**From:** [Trish](#)  
**To:** [Stonestreet Green Solar Project](#)  
**Cc:** [REDACTED]  
**Subject:** Interested Party 20049777 Comments on responses Stone Street Green Solar  
**Date:** 17 September 2025 21:05:02

I am writing to comments on two points which remain unanswered regarding the Stone Street Green Solar application.

CLIENT	EPL 001 LIMITED		
PROJECT	STONESTREET GREEN SOLAR		
DRAWING TITLE	ENVIRONMENTAL STATEMENT: 5(2)(a) FIGURE 14.4 NIGHT TIME 4.0m		
DRG No.	GM12014/Figure 14.4	REV	01
DRG SIZE	A2	SCALE	1:10000
		DATE	MAY 2024
DRAWN BY	DR	CHECKED BY	MJW
		APPROVED BY

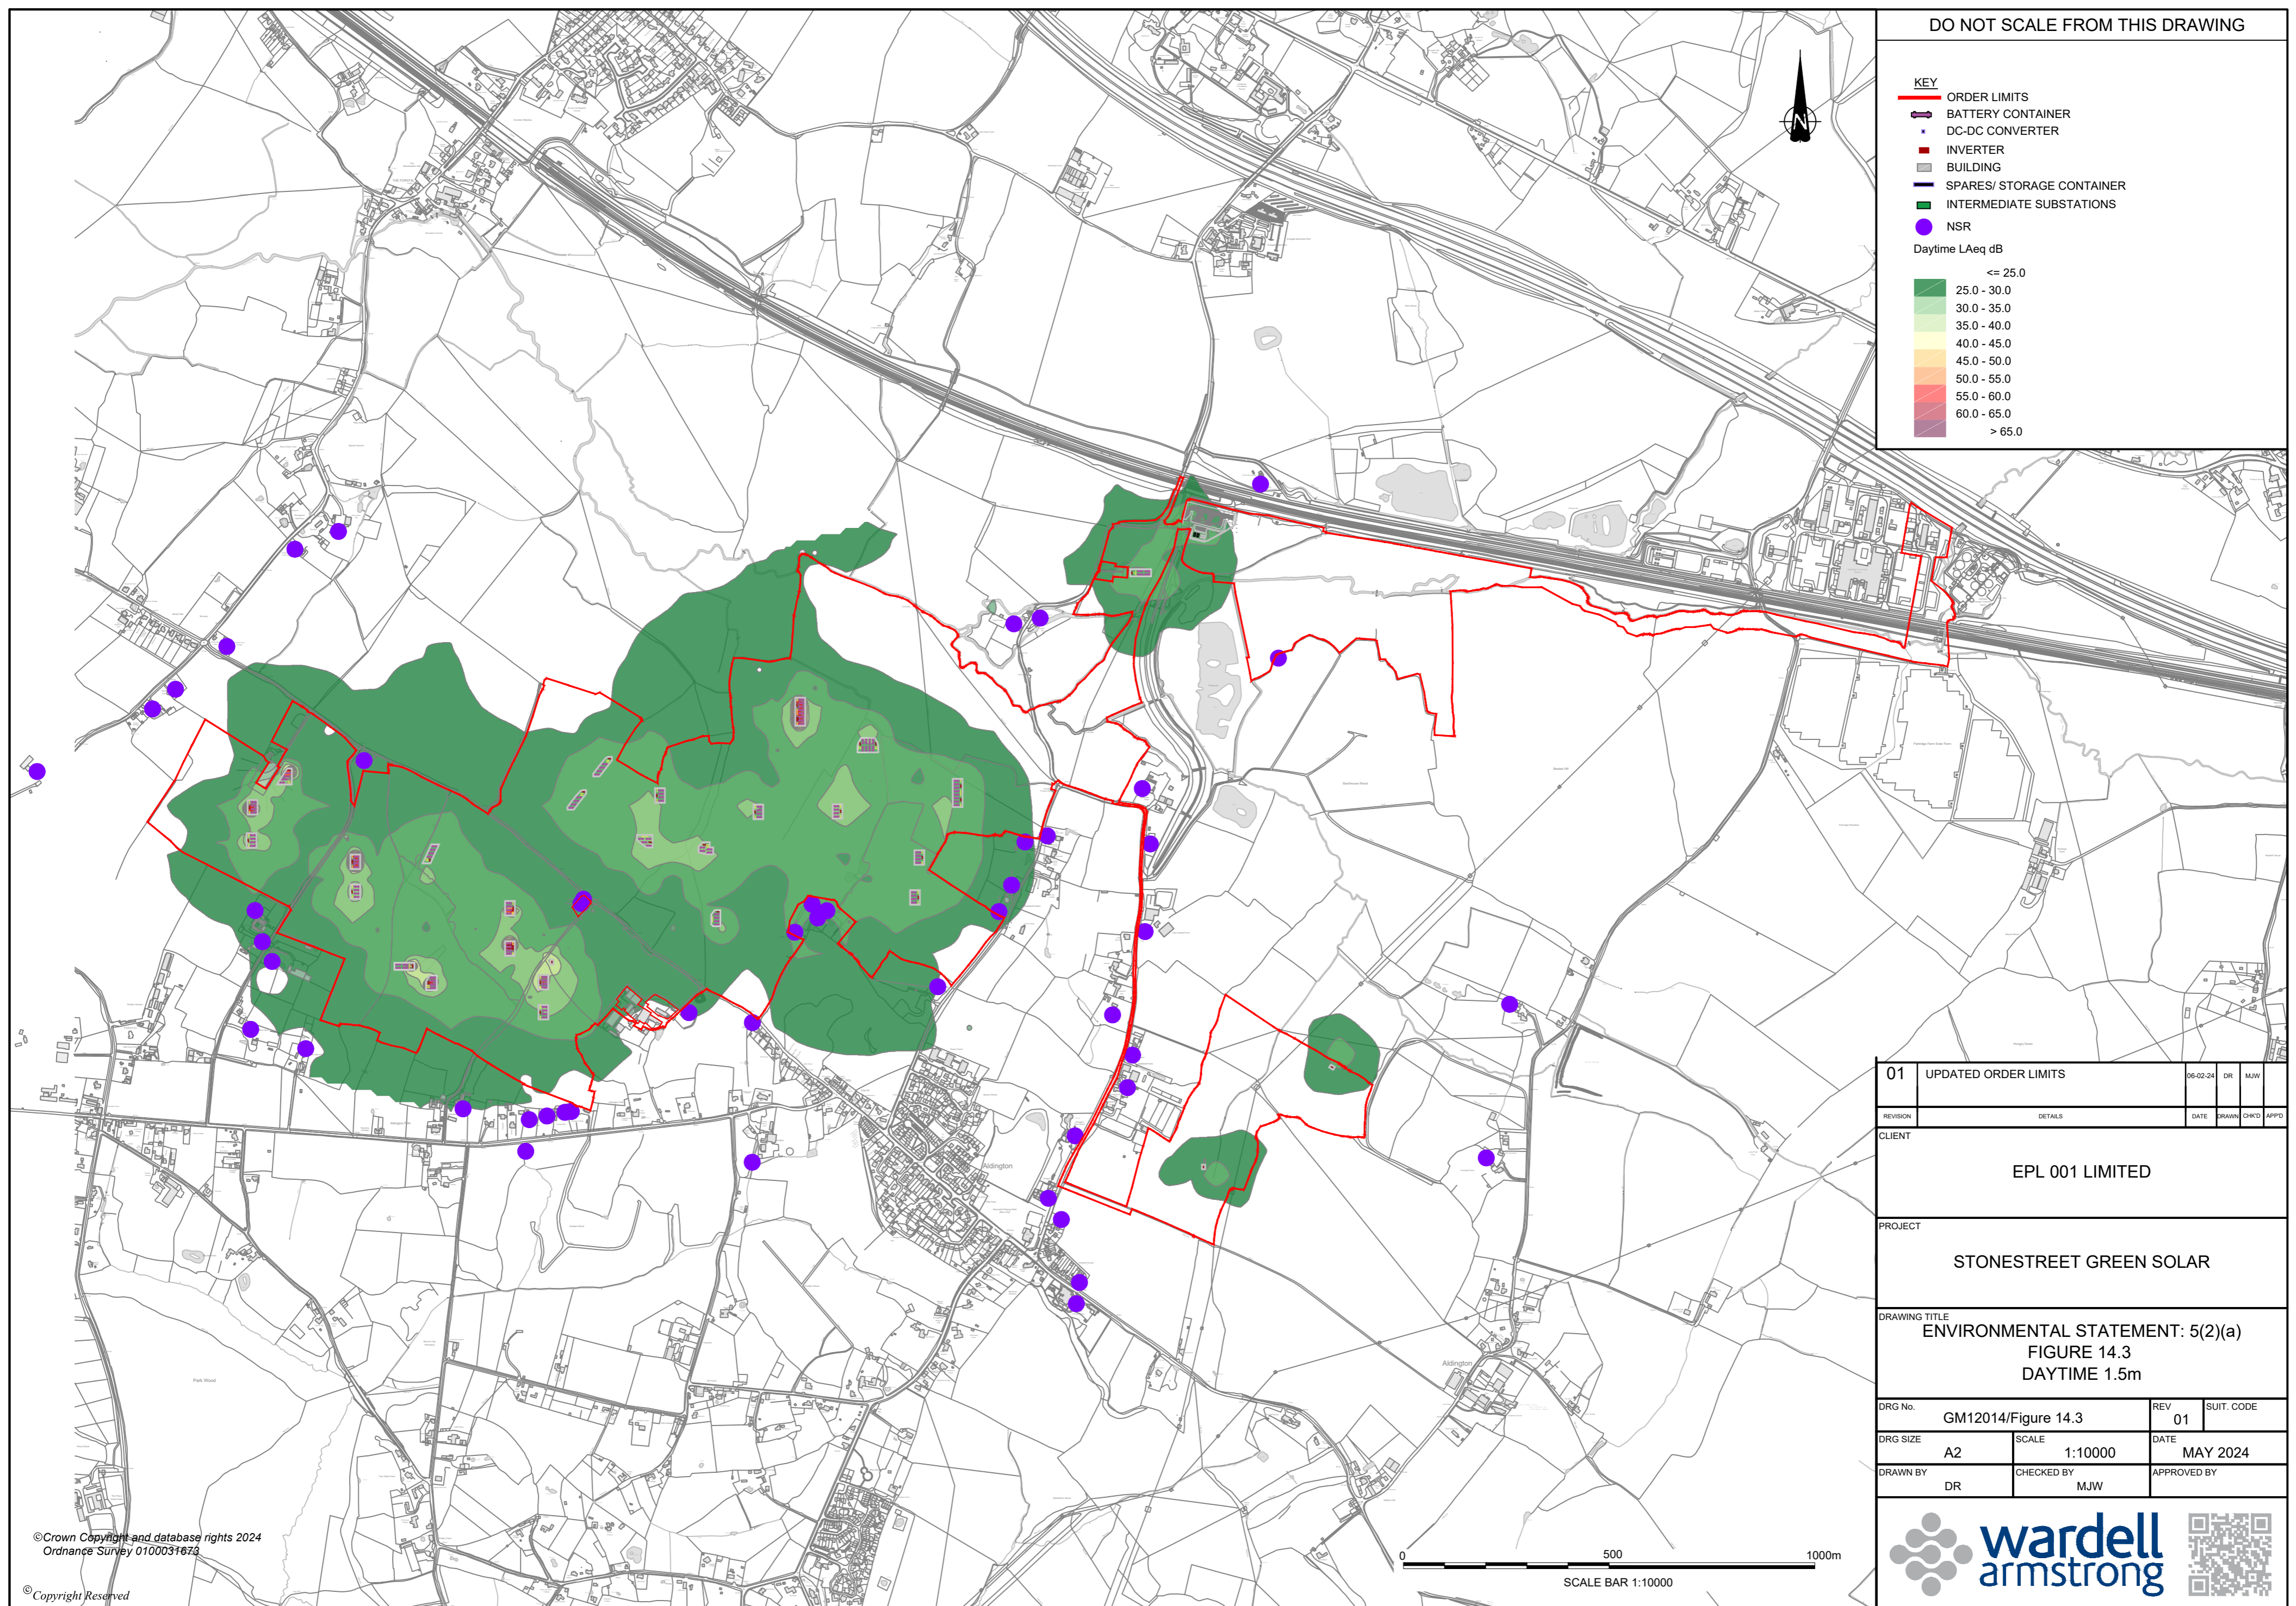
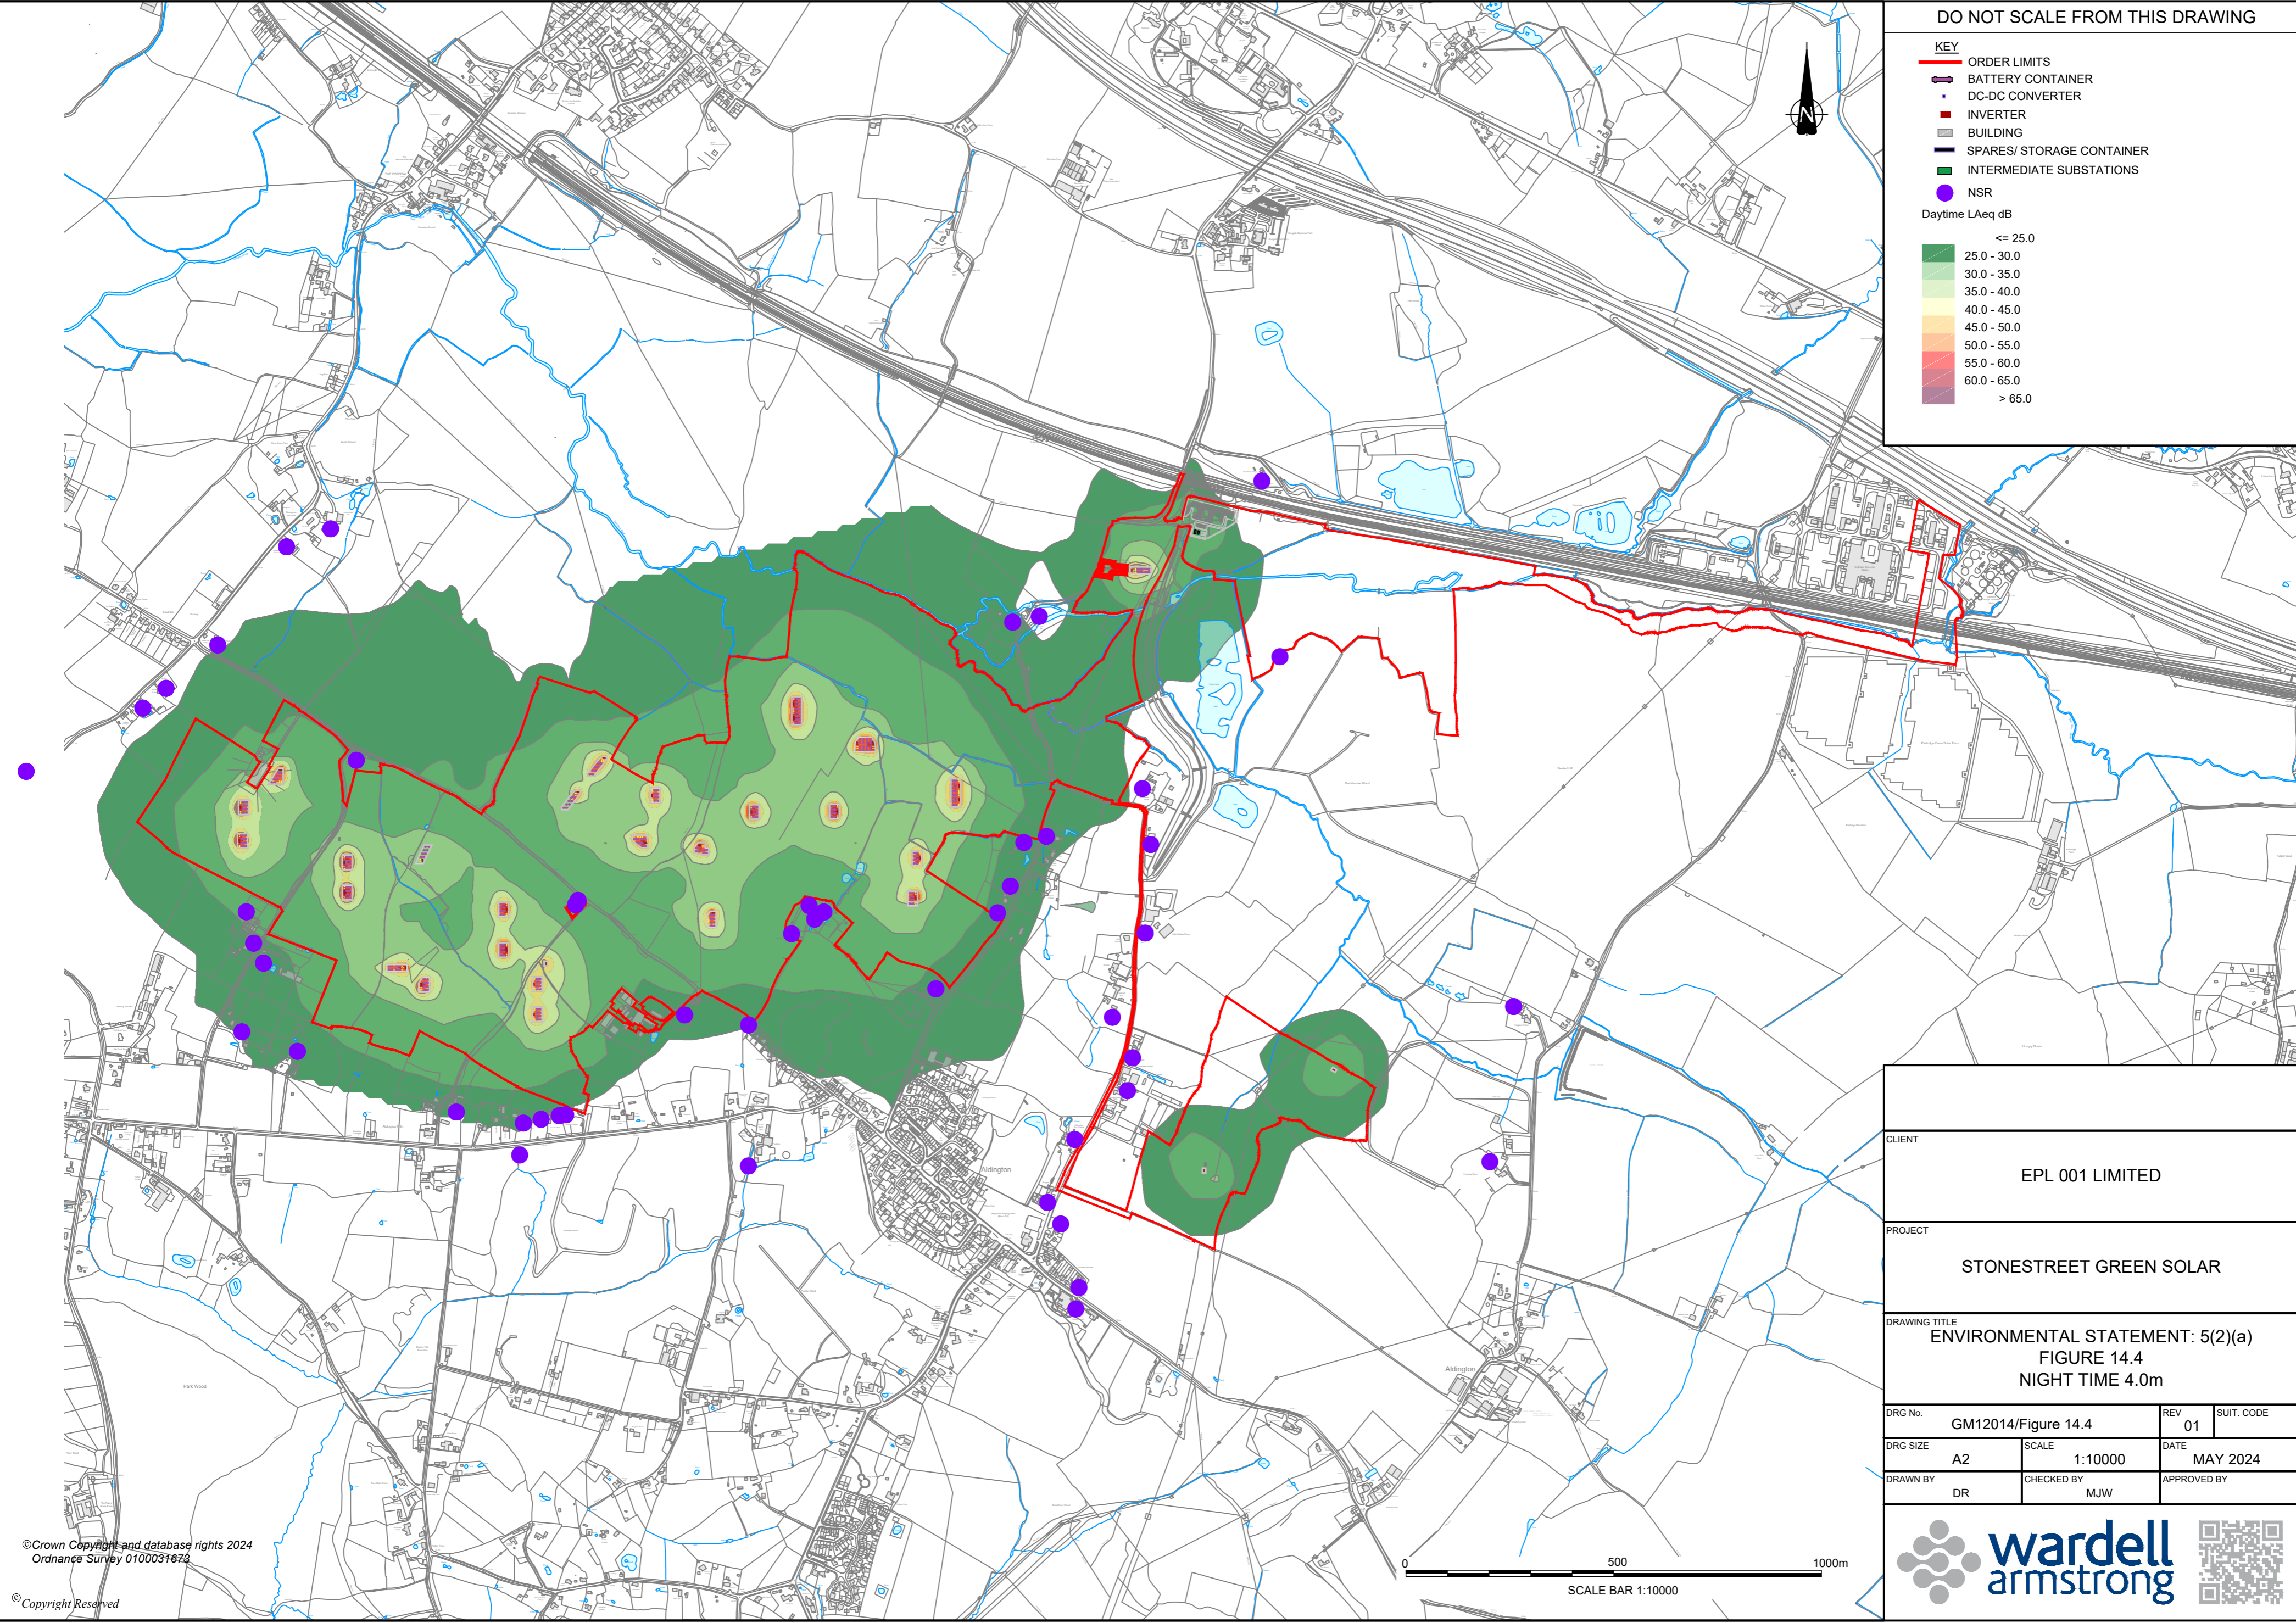
1) The consolidation of BESS units completely encircling my property ([REDACTED]) will result in continuous noise levels deemed damaging to health according to WHO figures. Despite being raised throughout the process, this concern remains unaddressed by the Applicant. They Applicant has presented unrealistic noise calculations which do not allow for the topography of the site or the cumulative effect of over 50 units within a few hundred metres of my home.
